City of Albuquerque

RE: TOWNE PLACE SUITES (L-16/D23G)
(2400 Centre Ave SE)
ENGINEERS CERTIFICATION FOR CERTIFICATE OF OCCUPANCY
ENGINEERS STAMP DATED 4/5/2002
ENGINEERS CERTIFICATION DATED 2/5/2003

**Re: Town Place Suites Grading and Drainage Plan, Lot 9-A
Engineer's Stamp Dated 1-9-02, (L16/D23G)**

Re: Town Place Suites Grading and Drainage Plan
Engineer's Stamp Dated 3-1-02, (L16/D23G)

C-1

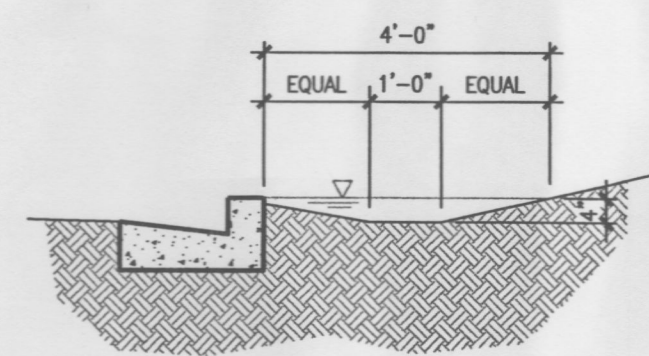
- Please quantify off-site flows from lot 9-B to Lot 9-A. Is the proposed concrete swale adequate to hold these off-site flows? Please show cross-section of swale.
- Please indicate if the contributing flow to Centre Avenue is within the allowable downstream capacity by supplying the basin map of the master plan. As you know each drainage submittal should be able to support itself.
